White Hill Wind Farm Electricity
Substation & Electricity Line

Annex 1.5: Carlow County Council Scoping Response

**RE: Your ref: WHI001SS.
Pre-Application Scoping Request for Proposed 110kV Electricity Substation &
Underground Electricity Cables in County Carlow & County Kilkenny.**

Drawing Title: FIGURE 5.04: ELECTRICITY SUBSTATION ENTRANCE DETAIL (1:400)

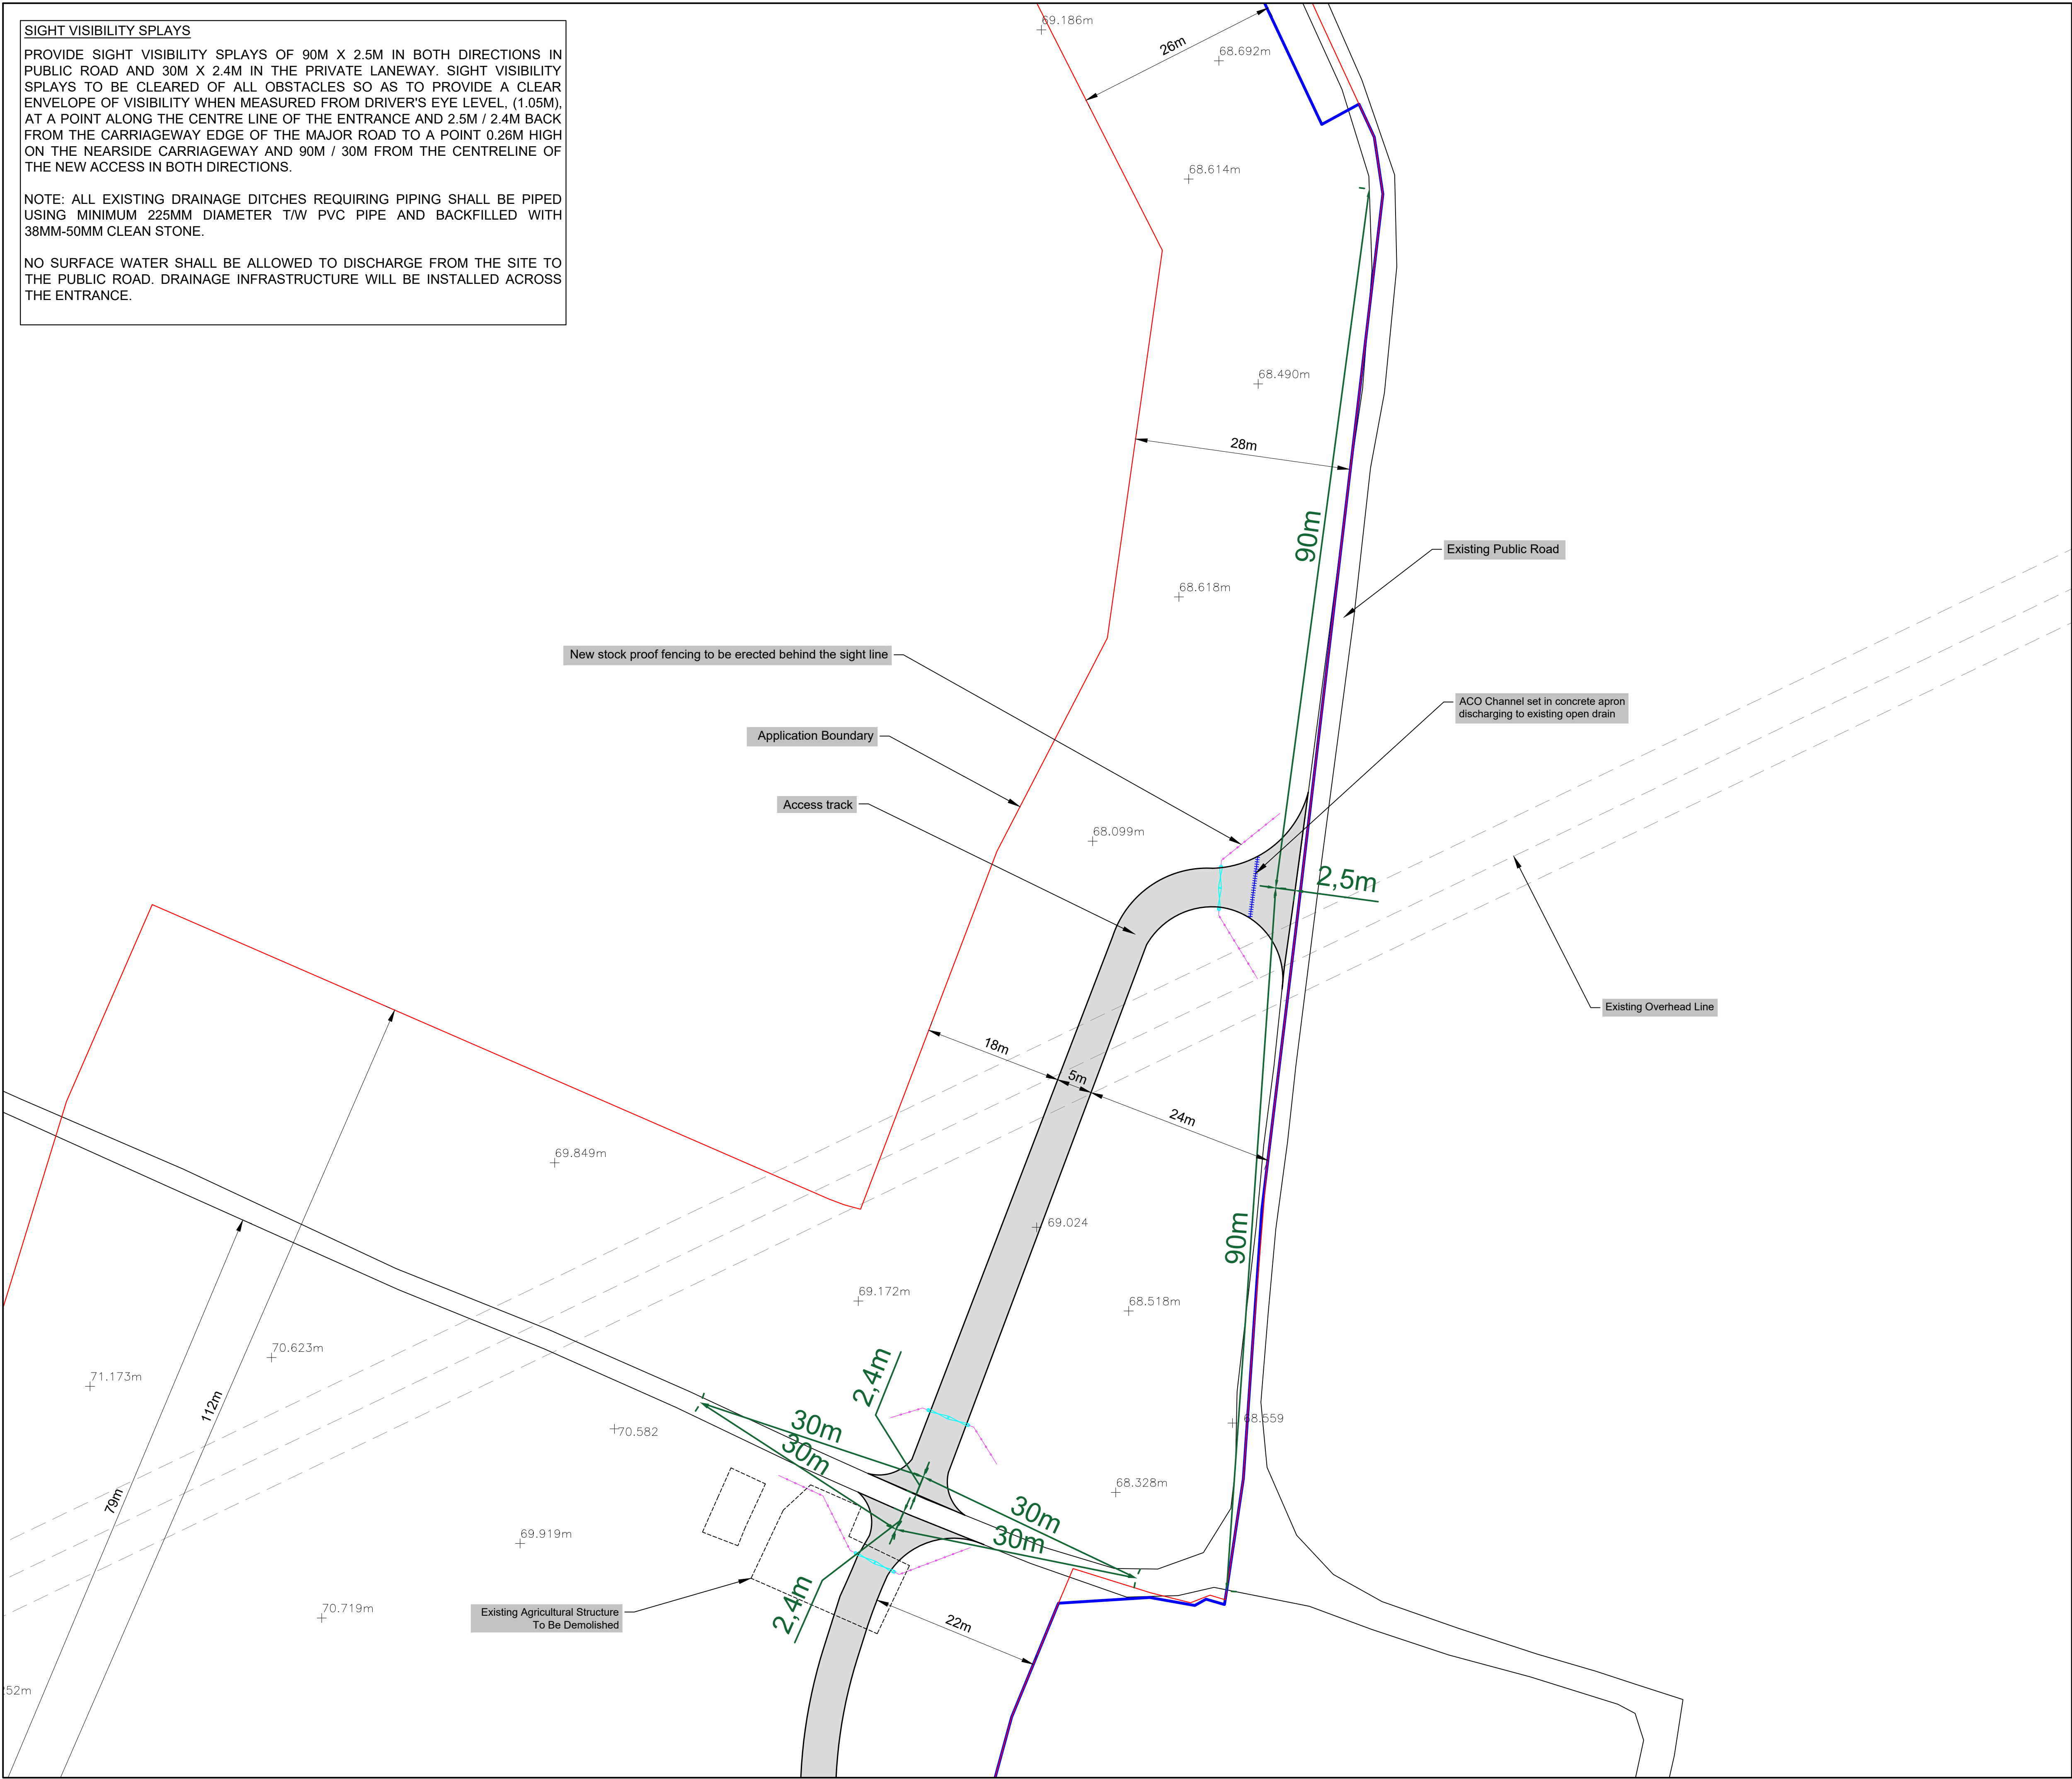
- Full design details for the entrance(s) to the substation site should be provided to demonstrate adequate turning movements for HGVs and sightlines. Accommodation works on third party lands must have written agreement of third-party landowners.
